From: [REDACTED]
To: [Manston Airport](#)
Subject: Manston Airport Examination Authority - Attn. Mr Broderick
Date: 07 June 2019 20:18:09
Attachments: [Sandwich & Pegwell Bay Nature Reserve Concerns re Manston Cargo Hub 4.docx](#)

PROPOSED CARGO HUB AT MANSTON AND ADVERSE EFFECT ON WILDLIFE IN THE AREA

Figure 12.6
Aircraft noise - daytime $L_{Aeq,16hr}$
contours - year of forecast maximum
capacity

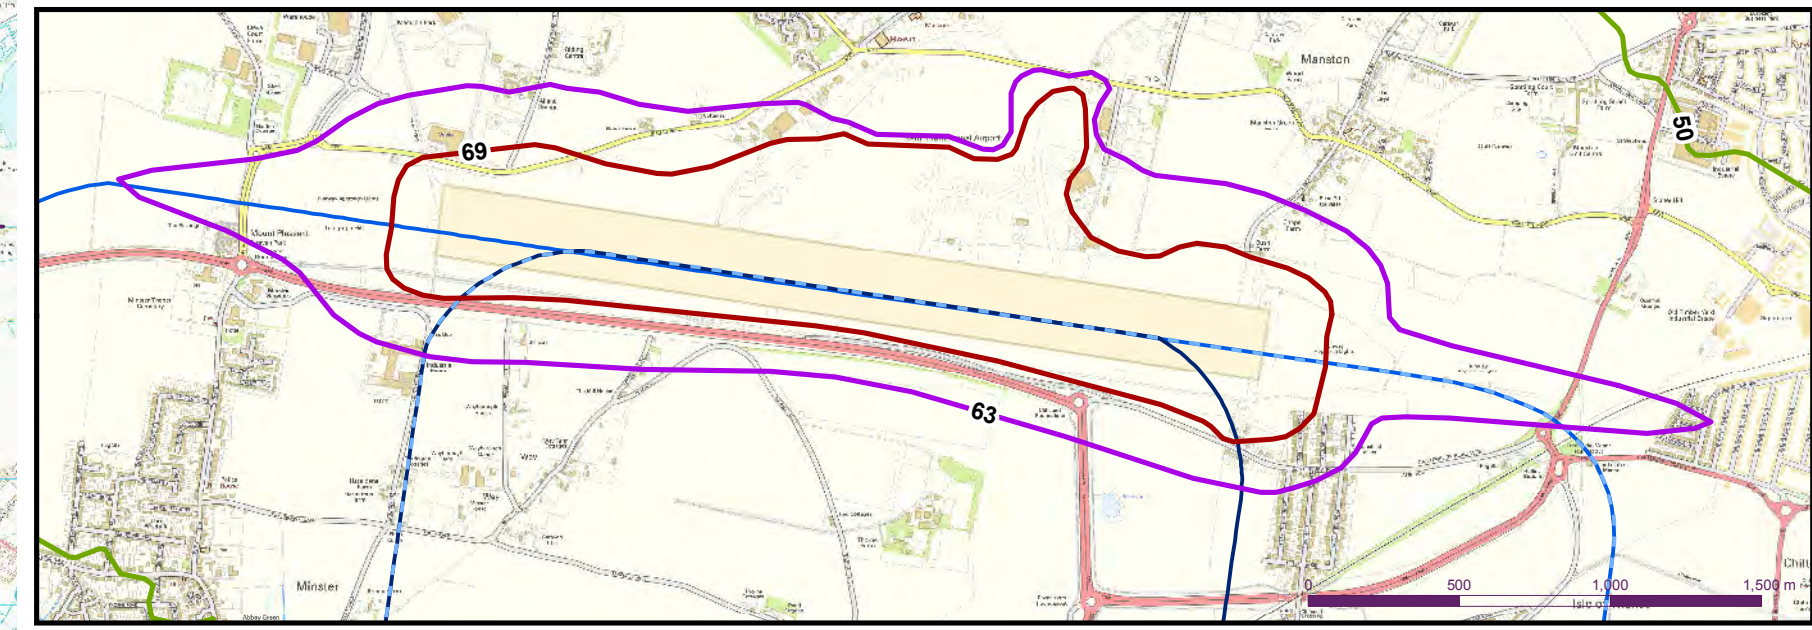
The proposed Manston Cargo Hub Airport will have a devastating effect on this vital area with constant noisy aircraft taking off and landing so close by. The applicants' contour map shows regular test and training flights will go right overhead the bay (TR020002/APP/5.2-4/Vol.4/Figs 12.4, 12.6 & 12.8), also flying at low altitudes which is likely to alarm and cause birds to take fright and fly upwards, possibly even getting struck by the aircraft itself.
